Our ref: DOC21/498855-3

Your ref: SSD 10447

Tomago Resource Recovery Facility and Truck Depot (SSD 10447) – Response to submissions

BCD's detailed comments

Figure 1: Evacuation diagram

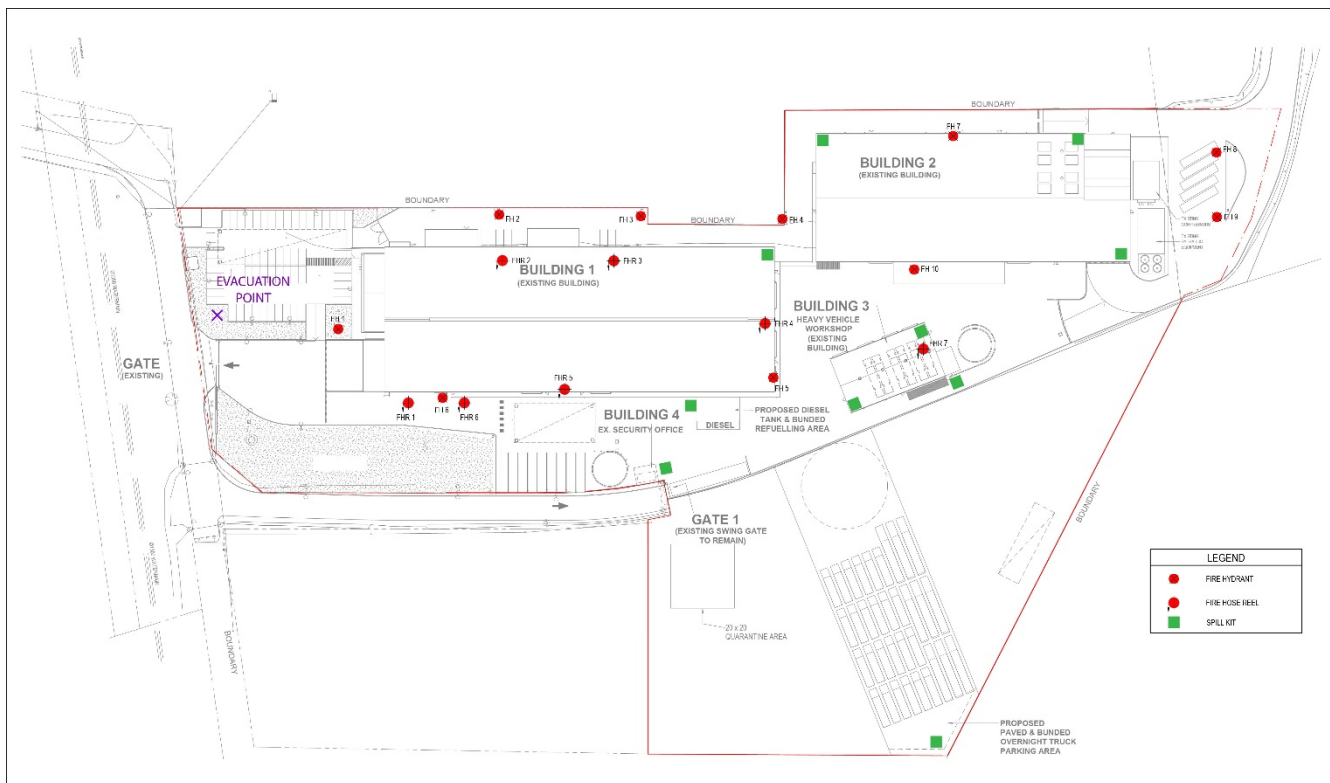
- Clear triggers: The EMP trigger for flood risk mitigation actions is when the Chief Warden determines that flood waters may reach the site boundaries. However, it is likely that flood preparedness will be a low priority for the Chief Warden, or they may not have the skills to predict flood levels on the site. The EMP should provide clearer triggers for required flood actions, such as flood heights at a local gauge or receiving flood warnings from the Bureau of Meteorology.

- Risks to People: The site is a low flood island that becomes isolated in rare flood events. The EMP should document actions required to maintain the personal safety of the occupants of the facilities, such as when to evacuate and instructions not to enter floodwaters.

- Description of the flood risk: The EMP should include a description of the site's flood risks, including identification of evacuation routes, and estimation of the likely warning time available to secure hazardous goods and evacuate occupants.

1. provide clear triggers for flood actions
2. include actions to reduce risks to people.
